From: Laura Gibbons <Laura.Gibbons@arun.gov.uk>
Sent: 05 April 2022 11:13
To: Planning.Responses <Planning.Responses@arun.gov.uk>
Cc: David Easton <David.Easton@arun.gov.uk>
Subject: RE: Planning Consultation on: Y/33/22/DOC

Engineers Comments Regarding Condition 9

Description of Works: Approval of details reserved by condition imposed under ref Y/91/17/OUT relating to Condition No 9 - surface water drainage.

FLOW CONTROL CHAMBER
(Scale 1:20)

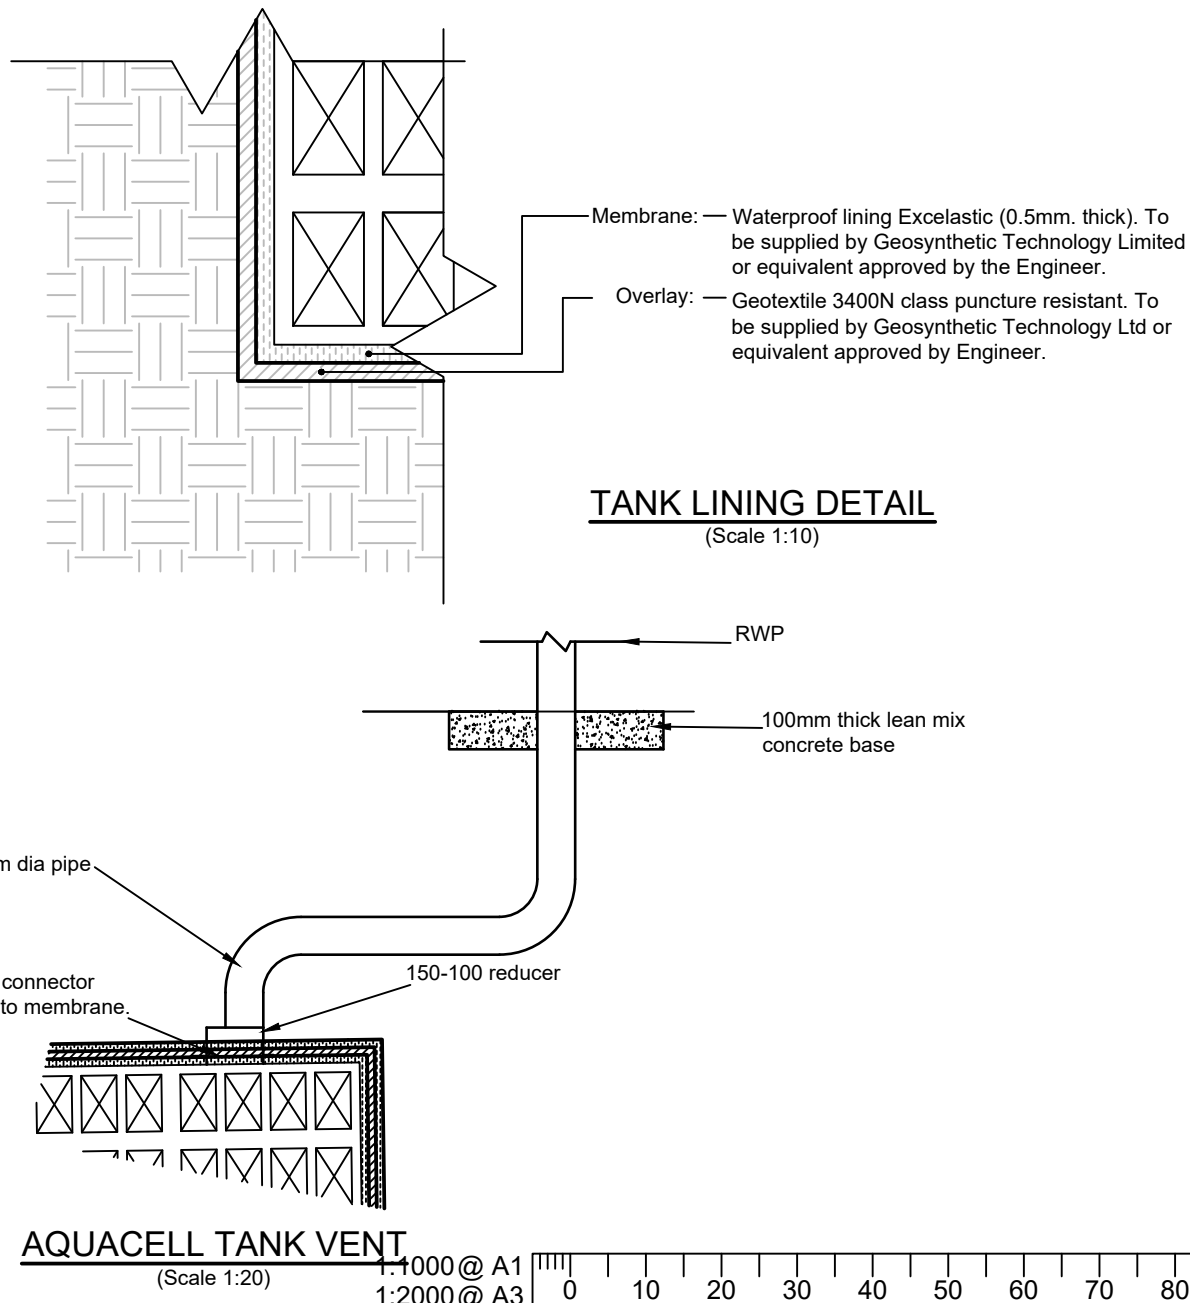
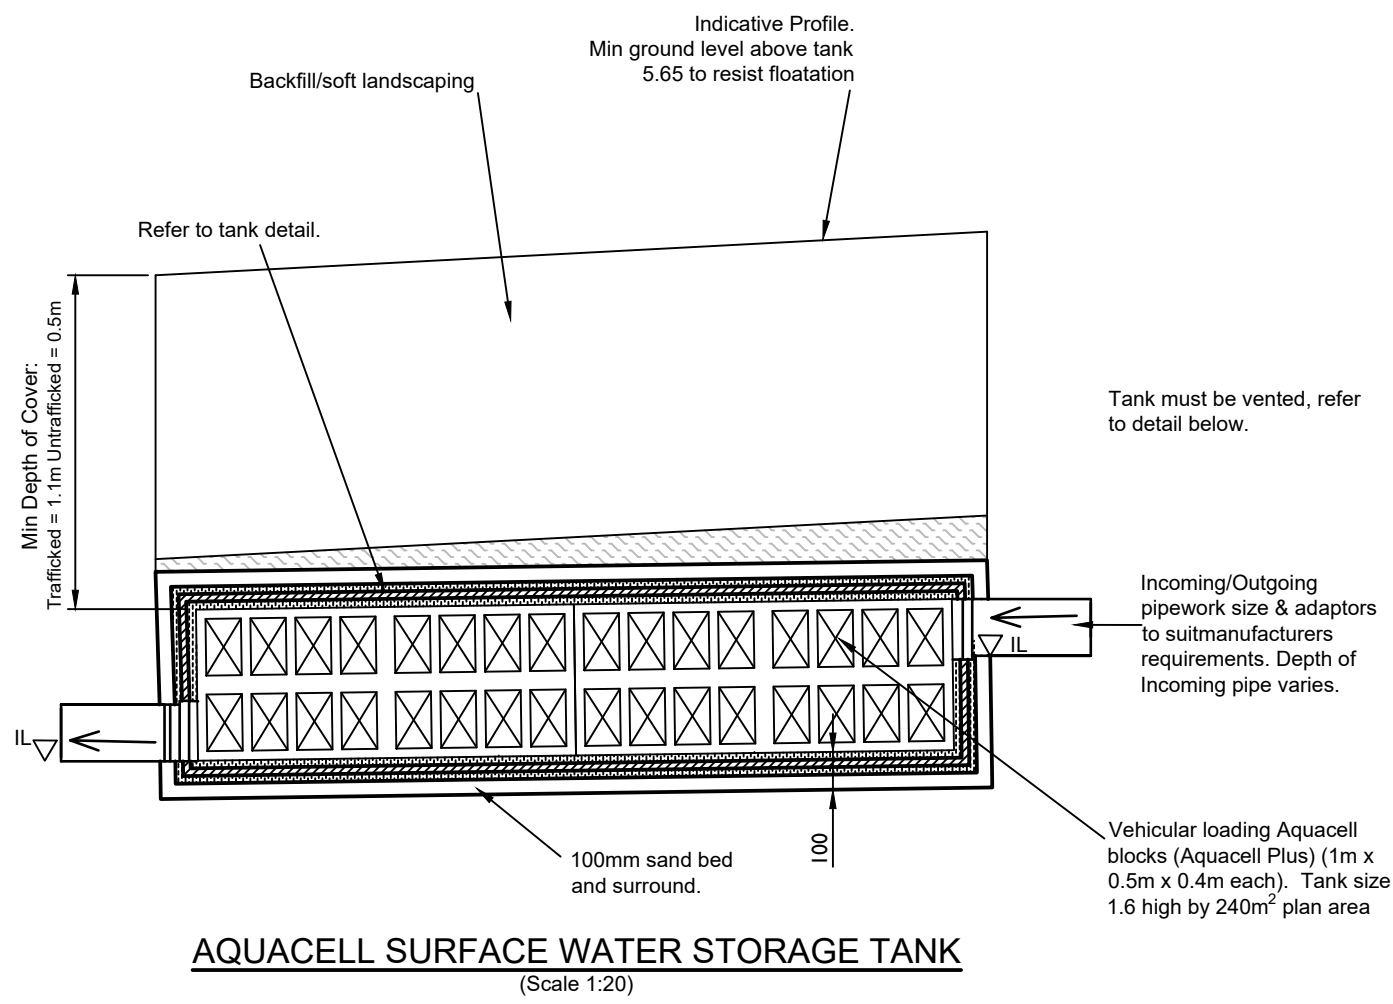
11. Please provide cranked grilles at a 45 degree angle.
12. Please detail invert levels of hydrobrakes and invert levels of overflows for each flow control device on the detail drawing.
